DRB CASE ACTION LOG (PREL/FINAL)

DRB Application No.: 08DRB-70245

Project Name: EXECUTIVE PLAZA ADDITION

**CITY OF ALBUQUERQUE
PLANNING DEPARTMENT
June 4, 2008
DRB Comments**

Existing Site Plan with Proposed Re-Plat Shown
4101 - 4263 Montgomery Blvd. NE

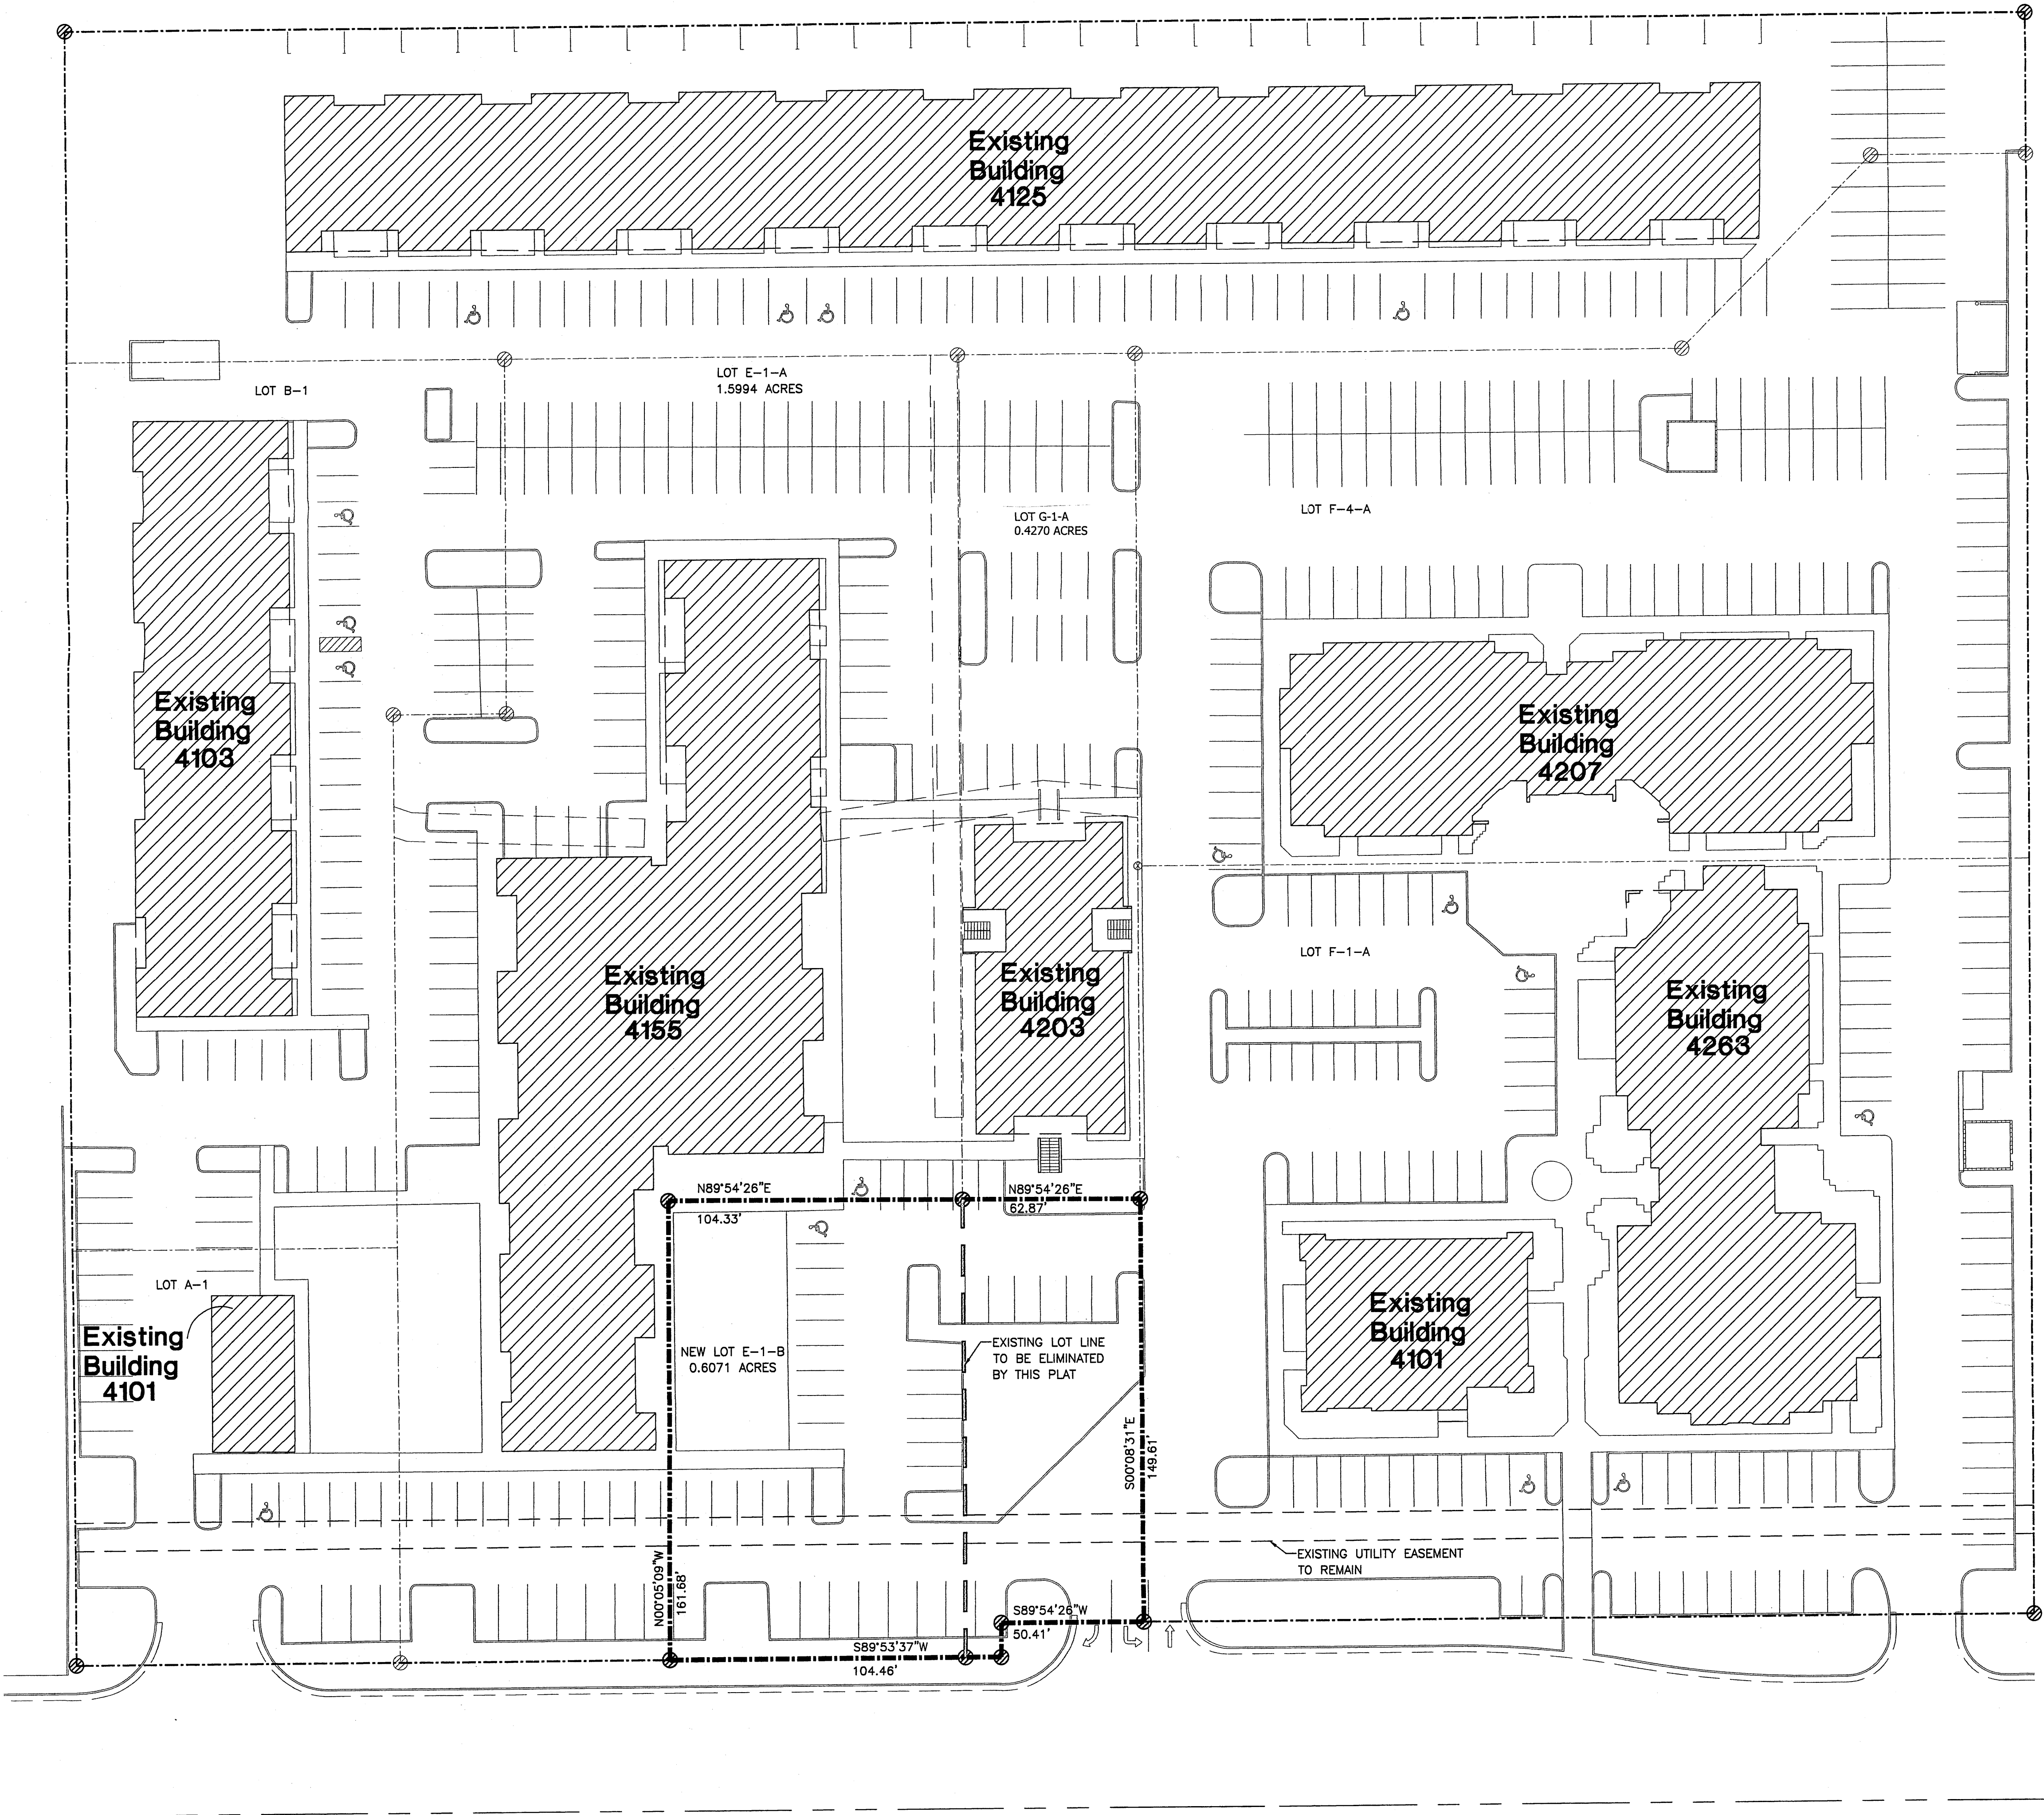
Per the Subdivision Ordinance, the proposed plat must conform with an EPC approved SITE DEVELOPMENT PLAN FOR SUBDIVISION.

PLAT OF
LOTS E-1-A, E-1-B & G-1-A
EXECUTIVE PLAZA ADDITION
 PROJECTED SECTION 35, T. 10 N., R. 3 E., N.M.P.M.
 ELENA GALLEGOS GRANT
 CITY OF ALBUQUERQUE
 BERNALILLO COUNTY, NEW MEXICO
 AUGUST 2007
 SHEET 2 OF 2

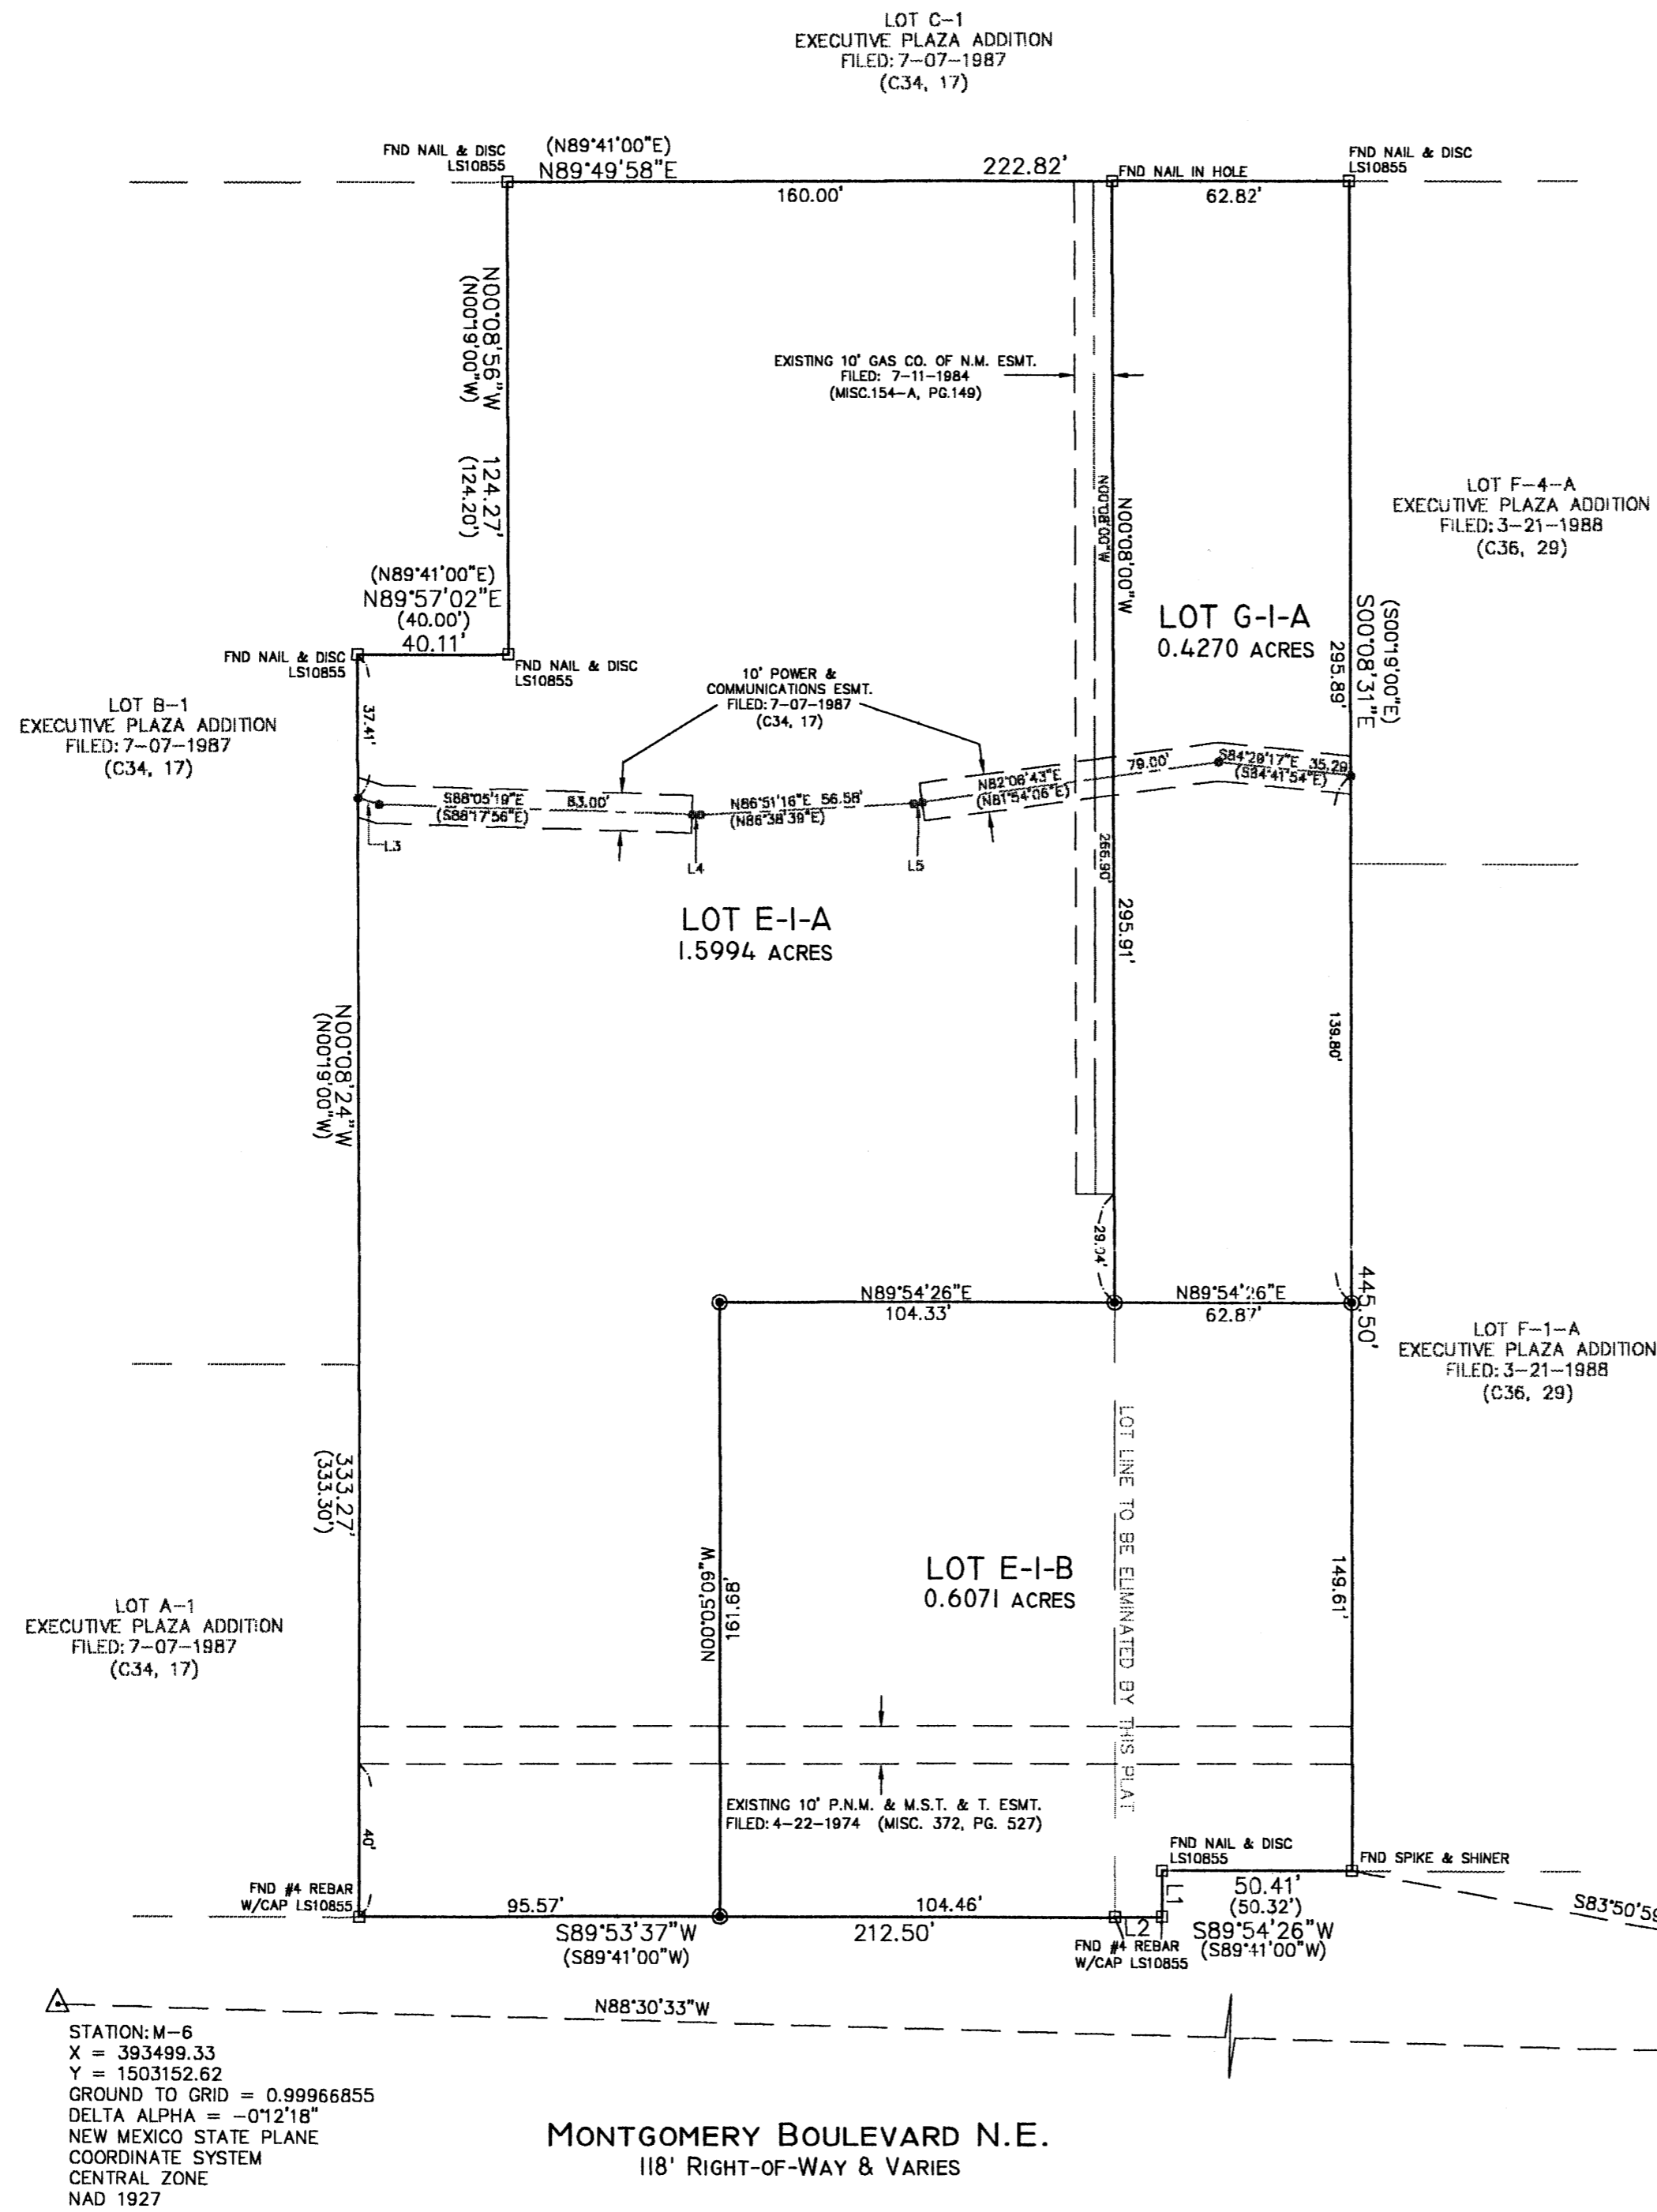
Provide copy of existing access esmt
Define ROW width
Exhibit showing dist from FC to PL

Need cross-lot drainage easement.
